Sent: 29 March 2013 12:08
To: Planning
Subject: Welwyn Hatfield Council Online Planning - Comment

Application Number: S6/2013/0233/FP
Name: R Jowett
Address: 47 Kentish Lane
Comment Type: Observation

PROPOSED SIDE ELEVATION

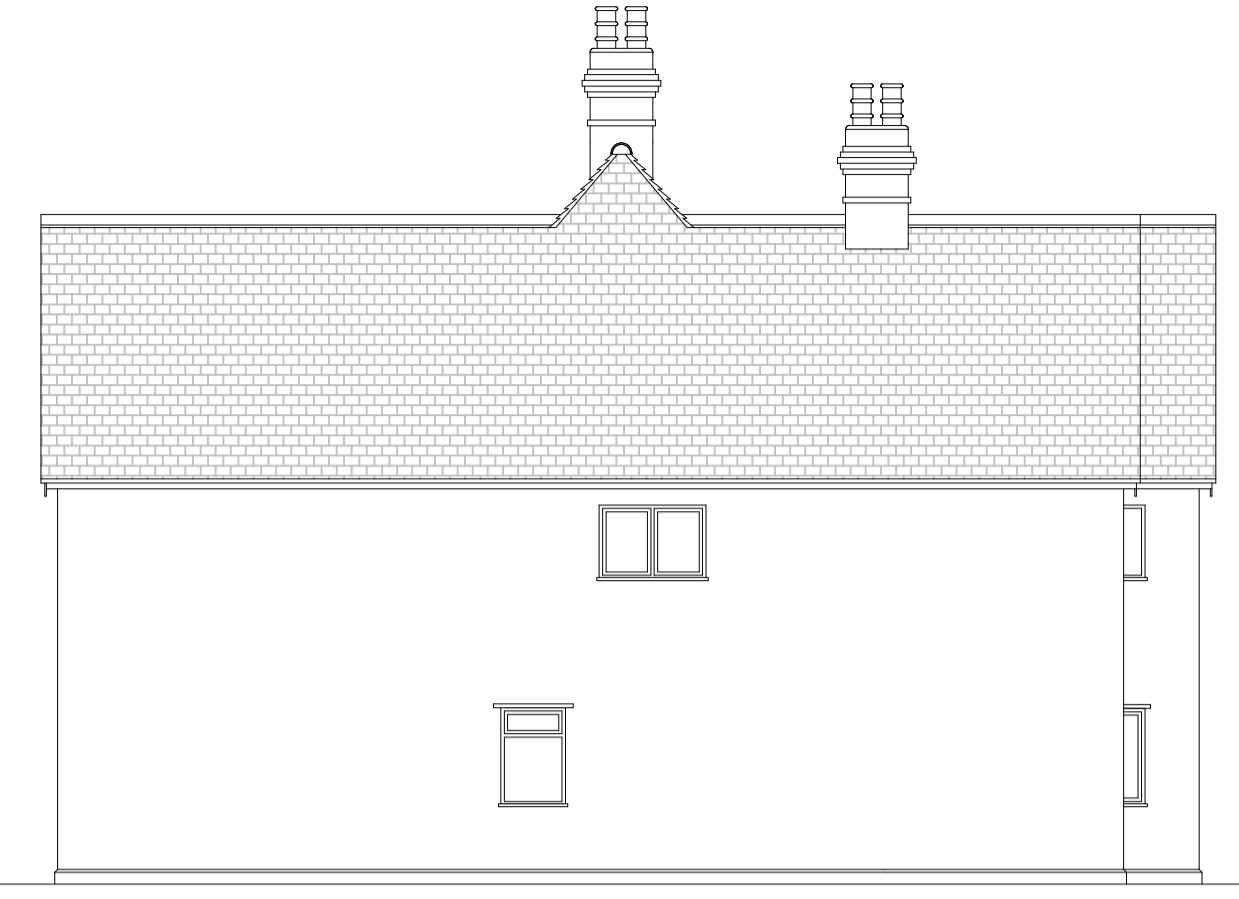
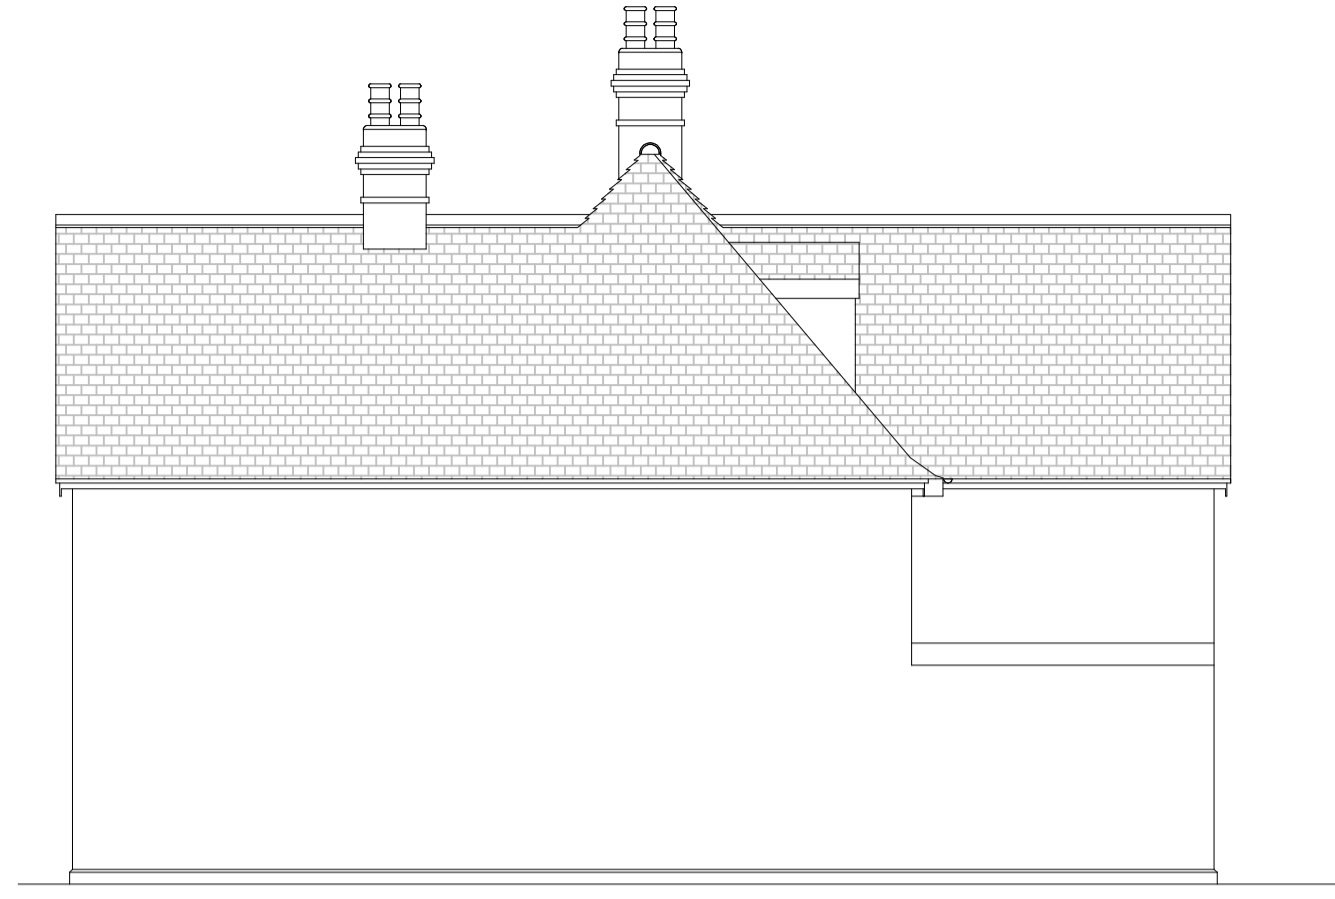
Comment: I think the proposal is generally in keeping with the style of the original house and scale of other properties in the road.
I am surprised they have started the work already.
I trust that the flat roof on the north east corner cannot be a balcony. I note also that the plans show two windows and a door on the north east wall ground floor level, not shown on the elevation. Are there any restrictions applicable to those?
